CITY OF ALBUQUERQUE

November 29, 2018

Re: Car wash Vacuum
500 Coors Blvd. NW
Traffic Circulation Layout
Engineer's/Architect's Stamp **11-19-18** (J10D041)

SITE PLAN

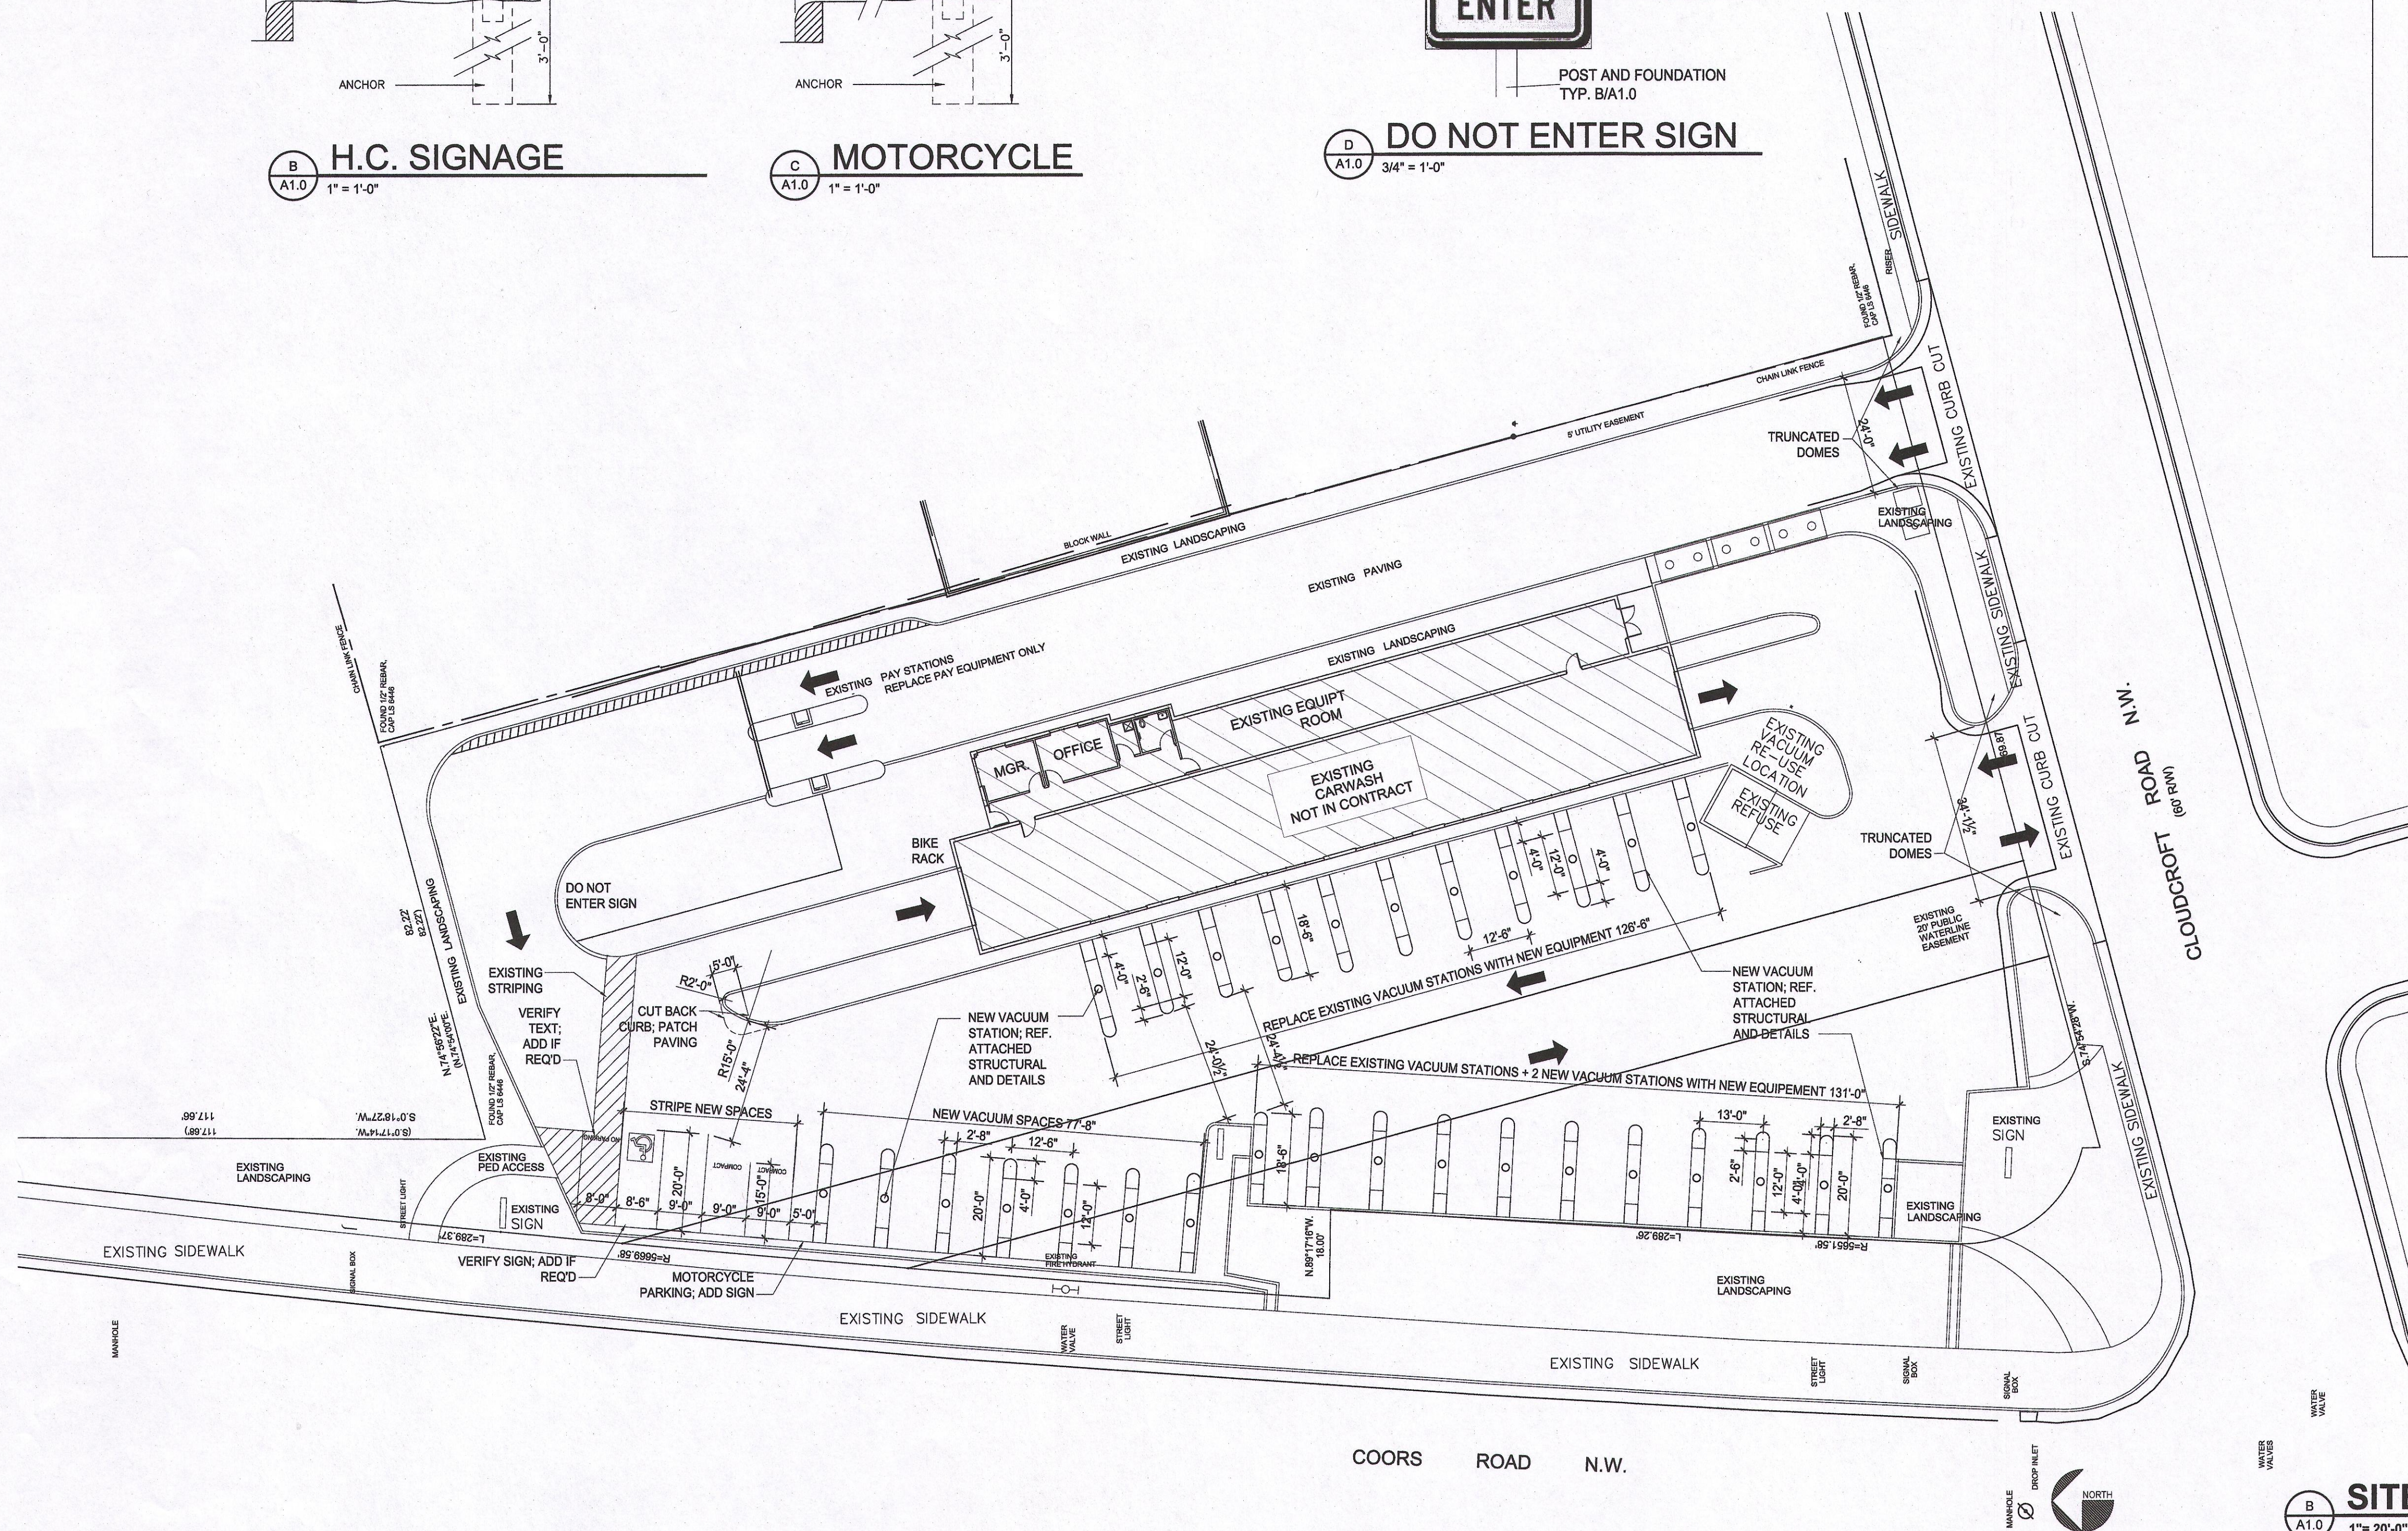
1. List the number of parking spaces required by the zoning code as well as the proposed number of parking spaces.
2. Identify all existing widths for all entrances.
3. Please list the width and length for all existing parking spaces. Some dimensions are not shown.
4. The handicap accessible spaces must be a minimum of 8.5 ft. in width. Please identify that.
5. The handicap accessible spaces must include an access aisle. Van accessible aisles should be 8ft wide; all others should be 5ft wide. Please verify the dimension.
6. Show all drive aisle widths .Some dimensions are not shown.
